# **Consultee Comments for Planning Application 24/00197/PLD**

Application Number: 24/00197/PLD

Address: 6 Butts Meadow Wisborough Green Billingshurst West Sussex RH14 0BU

Proposal: Single storey rear extension.

PROJECT	6 Butts Meadow RH14 0BU		CLIENT	Rogers	
SHEET	3D 1		Date	Issue Date	Scale (@ A3)
			Drawn by	SW	DRAWING NUMBER
			Checked by	SR	P 4
					REV

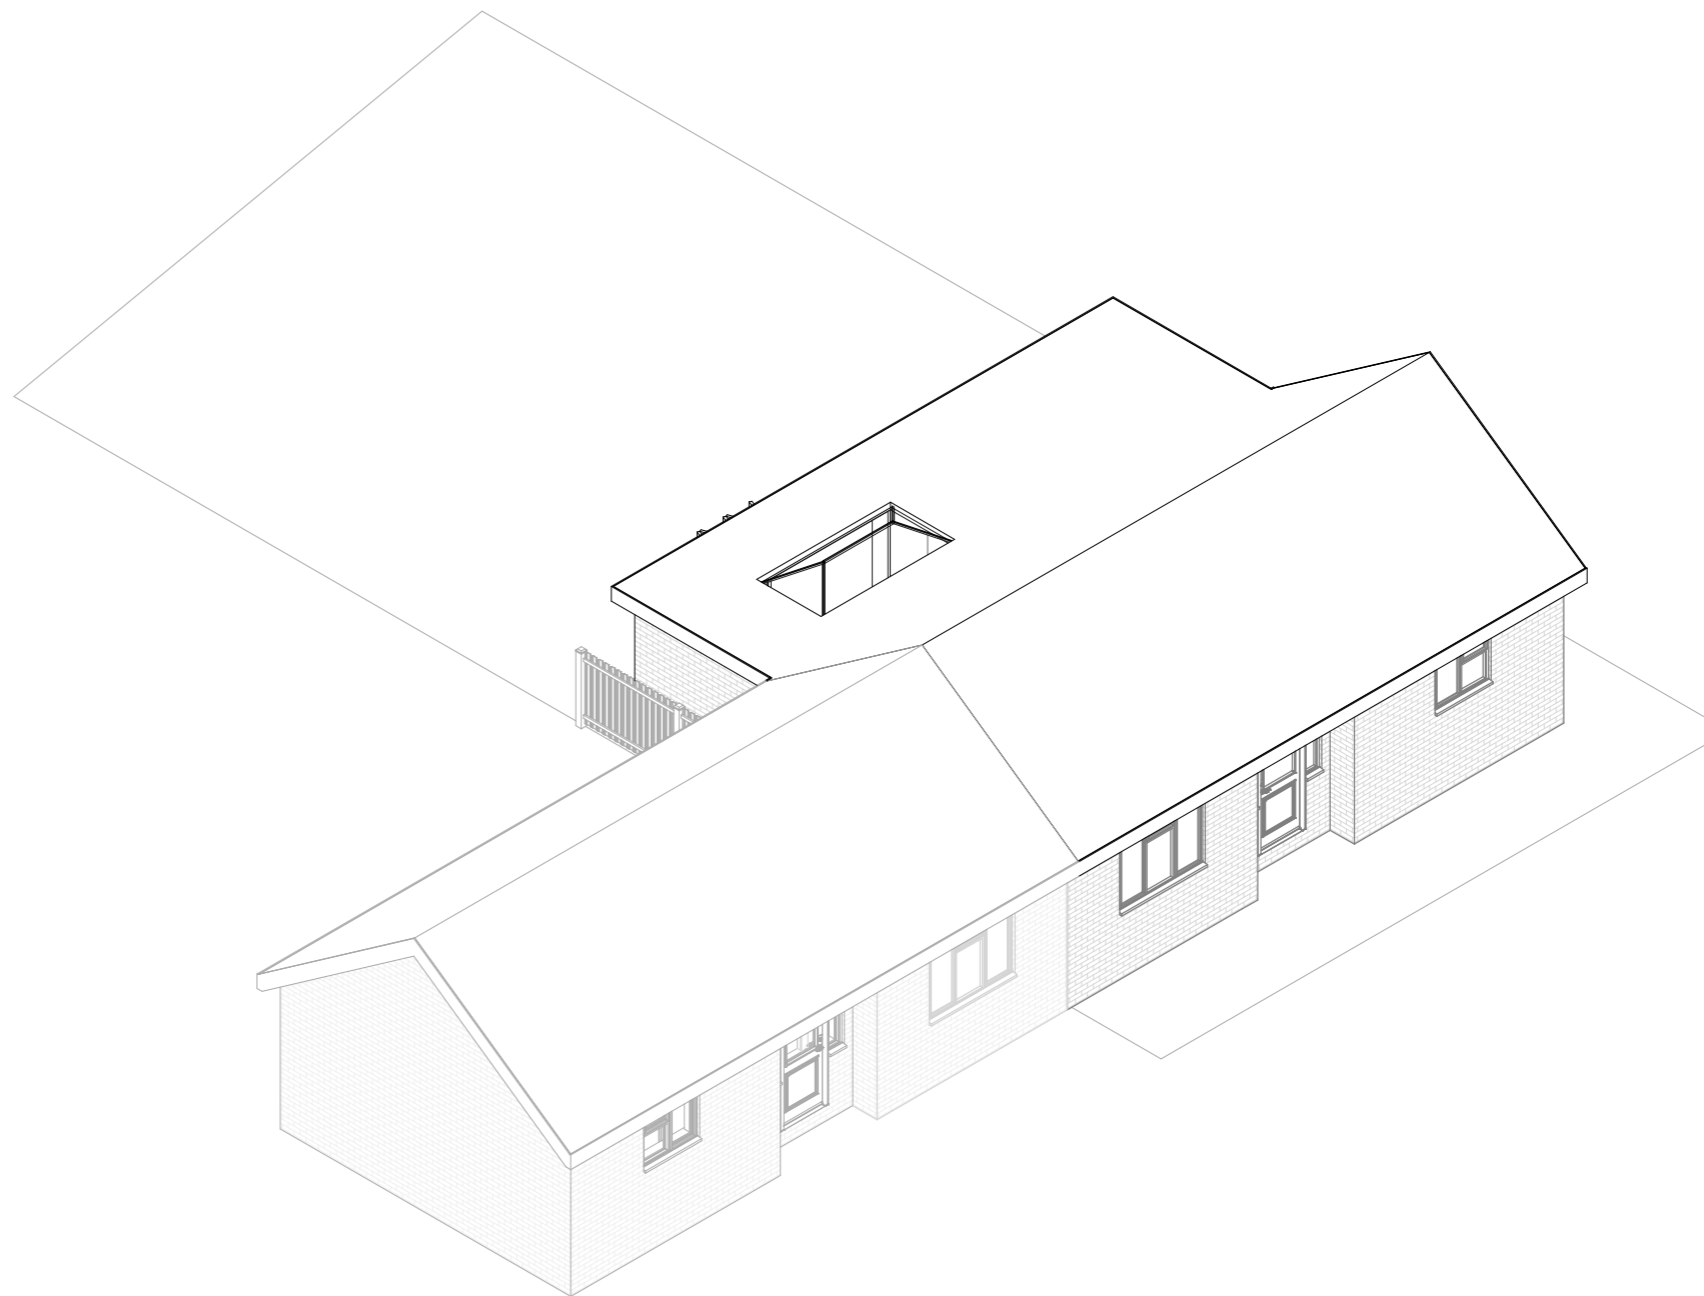
The Parish Council has no objection to this application, but in view of its support of dark sky policies and initiatives, would request that automatic dusk to dawn blinds be installed on the roof lantern to prevent the egress of light at night.
